Our Ref: LY/2/20/A
Your Ref:

Town & Country Planning (Control of Advertisement) (England) Regulations 2007 (as amended)
Application for Consent to Display an Advertisement(s)

Location McDonald's Restaurant Lyminster Road Lyminster

Location Plan

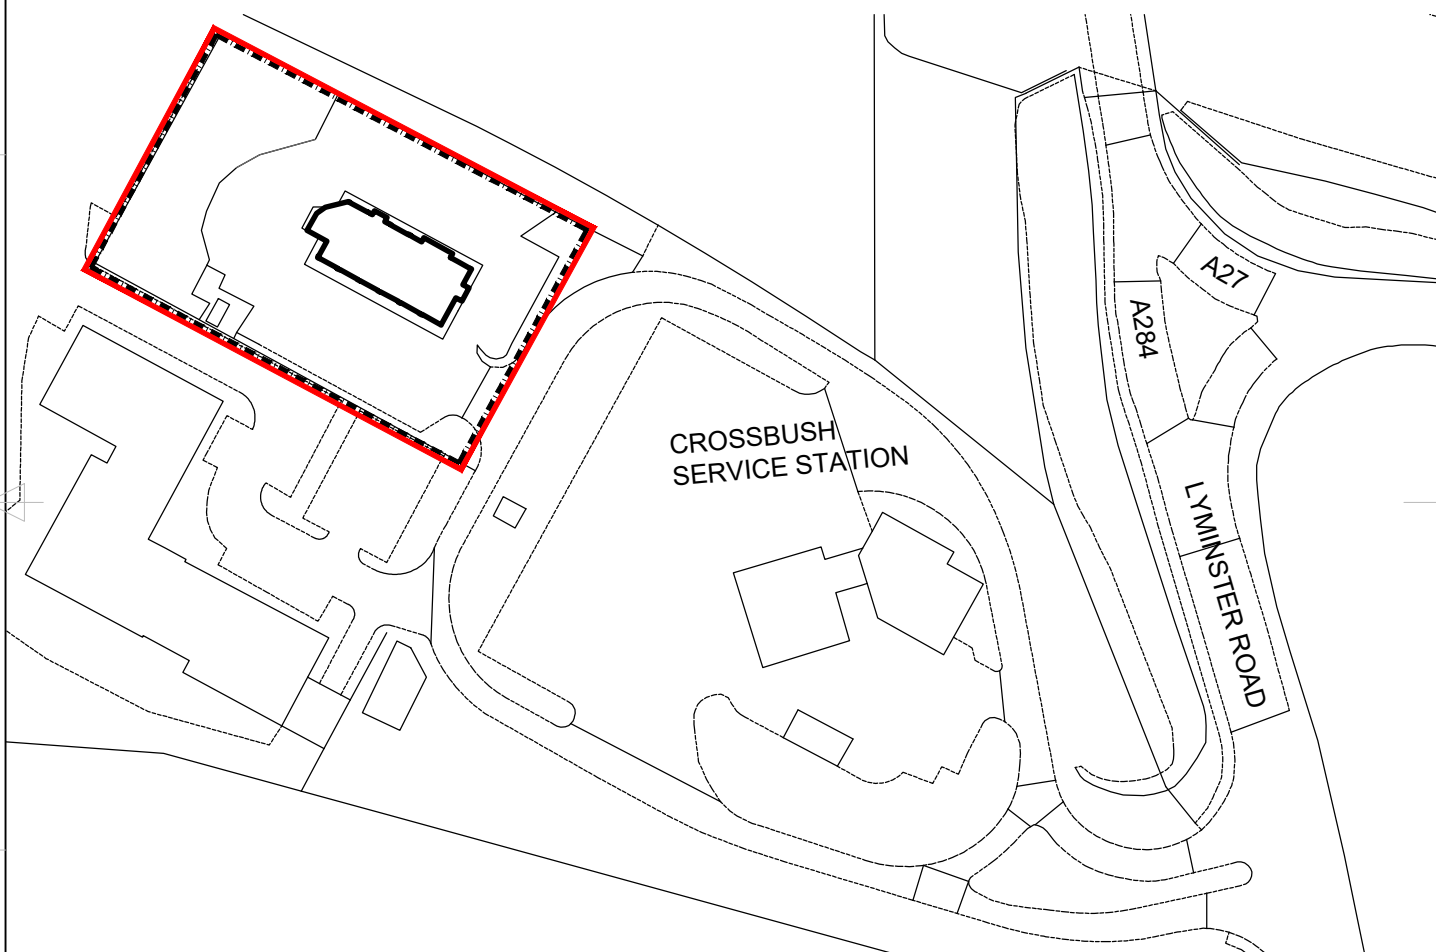
Location Plan: You are required to have 2 named roads on the location plan. Please amend.
